Your Ref: OWPC23814
Our Ref: FP/139/19/OUT 23-06-2019
Please ask for:
Maria Tomalova

Outline application with all matters reserved for the erection of 1 No. dwelling.
Land south of garage compound & East of 12 Alfriston Close Felpham

Thank you for your internet representation made on 29th July 2019 which has been recorded as '**an objection**' with the comments as follows:

Land East of 12, Alfriston Close, Felpham, West Sussex, PO22 6QB

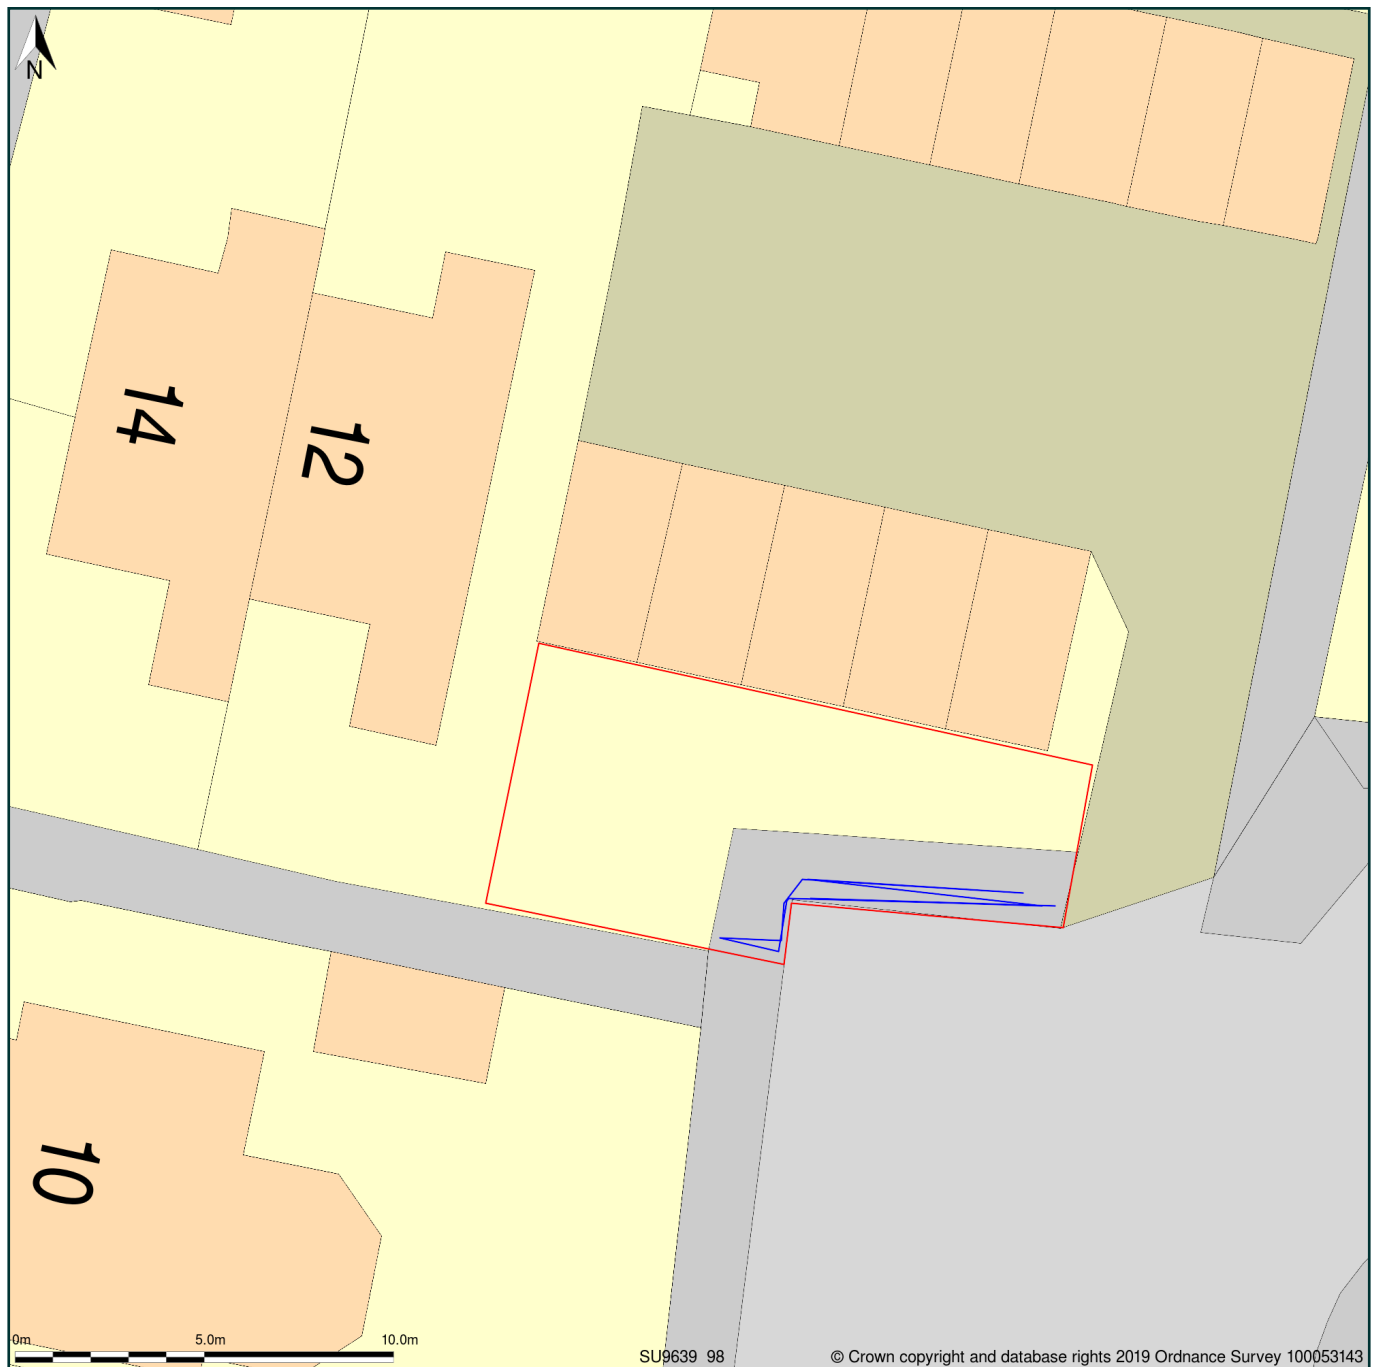
The block plan of the application shows that the current public footpath adjacent to the green space will be removed in favour of the property. This will restrict disabled access and public access to the two existing homes 12 and 14 Alfriston Close adjacent to the proposed build.

The planning application does not show the current position of the street lamp which sits on this green space and is invaluable to those who use the pathway and alleyways to access 12 and 14 Alfriston Close, 7 to 10 Fittleworth Drive and the garage compound.
